Subject: FW: AB/39/21/DOC - 19 Maltravers Street, Arundel

I am e-mailing you in respect of the above approval of details reserved by condition imposed under ref AB/125/20/L relating to Condition Nos 3 - details of junction between elevation of extension & flat roof including materials, 4 - materials & finishes for brick & brick bond, 5 - details of new external door including materials, finish & method of glazing, 6 - materials & finishes for rooflight and 7 - details of internal window including proposed glazing

Section A-A

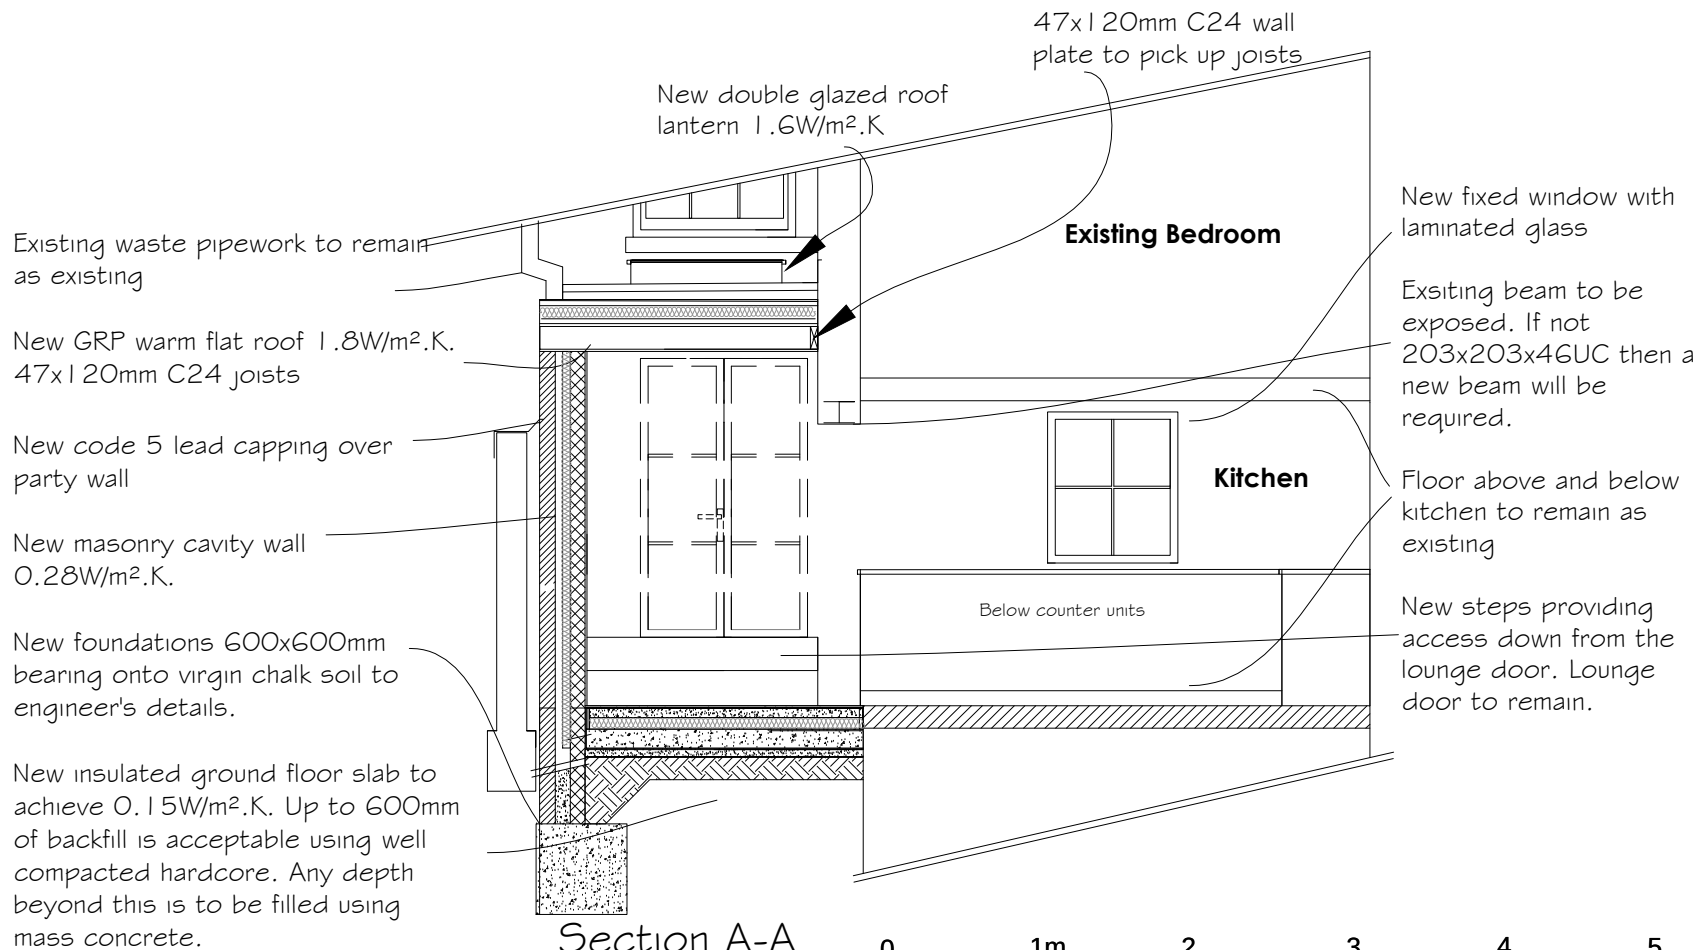
The rear elevation will be brickwork as discussed however, we did not discuss the side elevation which you can see in the attached photo. For all intents and purposes it would be better for this elevation to be rendered with a lime render and painted to match opposed to facing brickwork. Please confirm that this approach is acceptable to you.

In respect of condition 7 it would help to have further information regarding the interior window: what will the glazing bars look like? Will they be integral or applied to the frame?

I also note that the intention is to revise the treatment of the small areas either side of the rear elevation door from brick to render and use the same paint colour as already present on the listed building. Whilst this approach is likely to be acceptable, it can't be submitted as discharge of condition application since the treatment of the wall was detailed on the approved plans and there are no conditions relating to submission of render for approval. In order to make this change a new application for Listed Building Consent will need to be submitted for consideration.

This detail is not specifically referred to in the conditions. I will arrange for this response to you to be scanned against the DOC application and on the basis set out in Mr White's response the change can be logged against the approved details. However, if the area is greater than understood a separate application for the works may be required.

I have looked at the photograph and it would appear that the wall has already been built so as to be rendered! However, this appears to only be two rows of concrete blocks, and therefore covers a small area. If this is correct, I am happy for the change

The glazing bars will be an integral part of the frame with individual panes of glass.

The window will be joinery quality timber construction with laminated glass. The parting beads will be timber bevelled to match the sash detail to the front of the property.
